KITITAS COUNTY

MEMORANDUM

TO: All Staff
FROM: Kelee Hodges, Engineer Tech II on behalf of Justin Turnbull, County Surveyor
DATE: March 28, 2022
SUBJECT: County Survey Review of BL-22-00001 Colazo

ZEPEDA COLAZO PROPERTY

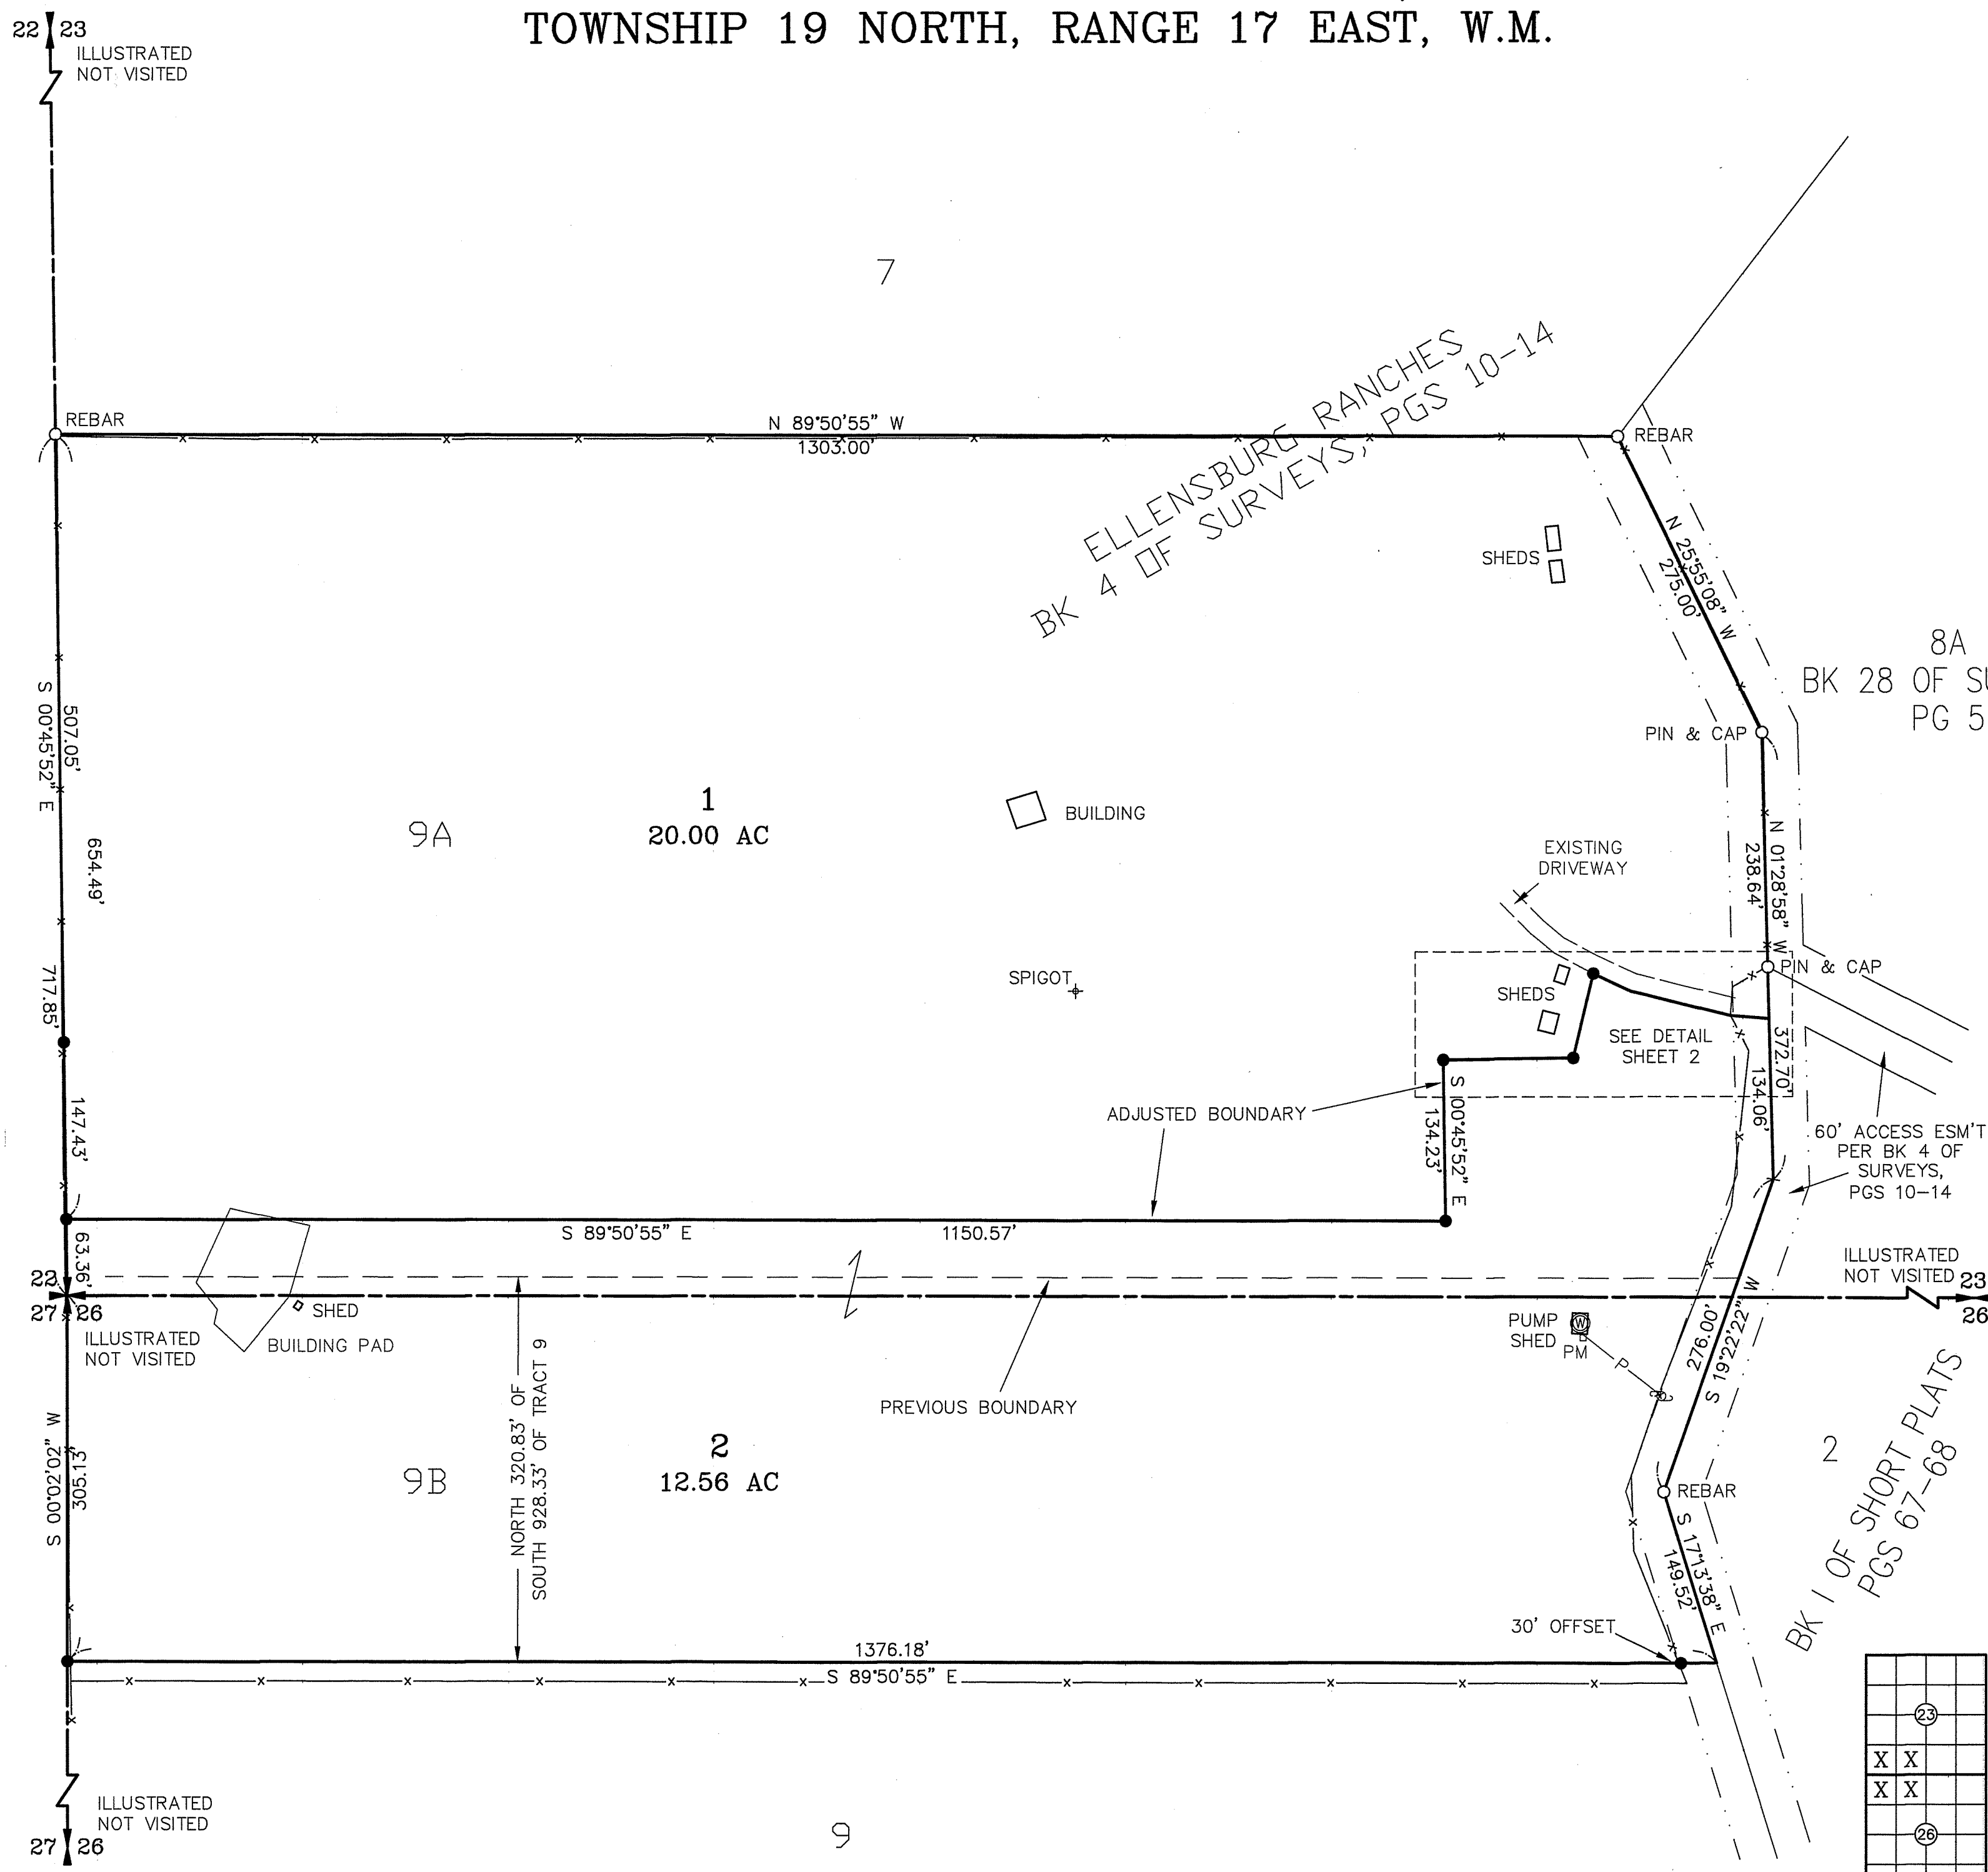
1. All roadways must show name, width, underlying ownership (Private/County/State), easement or right of way, and surfacing material.
 - a. Ellensburg Ranches Rd

2. All encroachments, usage lines, and trespasses shall be noted on the face of the survey, with a dimension to property boundaries per WAC:332-130-050(1)(f)(vii)
 - a. Building pad area shows along property line. Future development must meet property line setbacks.
 - b. Add a distance offset for the fence line that runs south of the southern boundary of Lot.
